The Discount Tyre and Battery Service

Planning Application Number BR/73/19/PL

Planning Application Number BR/73/19/PL

INDICATIVE ILLUSTRATIONS not to scale

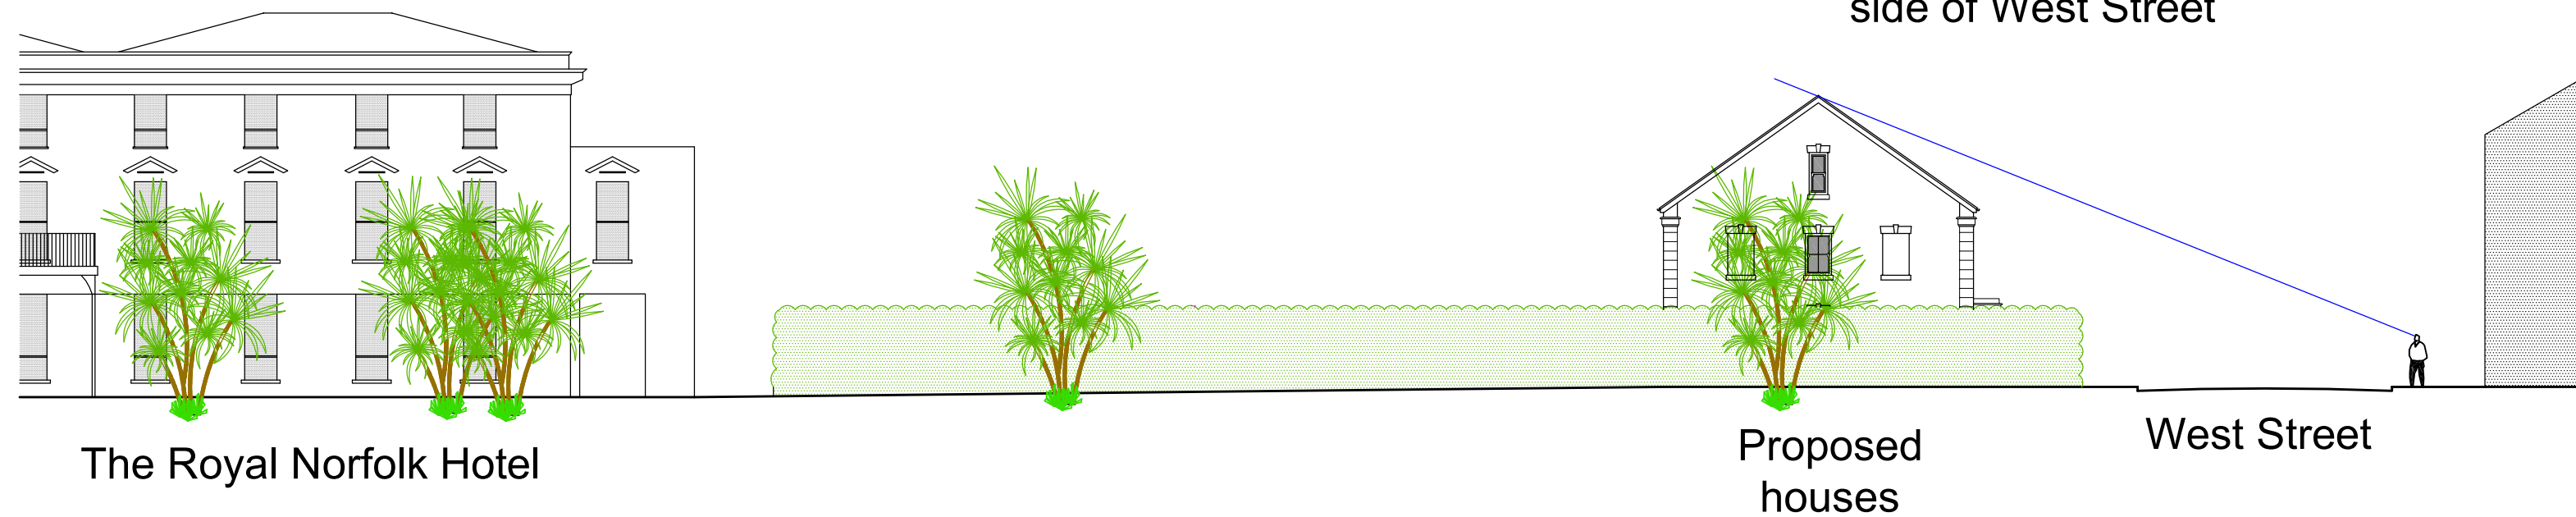
The new buildings are planned to be 2 stories, which makes it too high for this side of the street, as it will block the view of the Royal Norfolk Hotel from West Street.
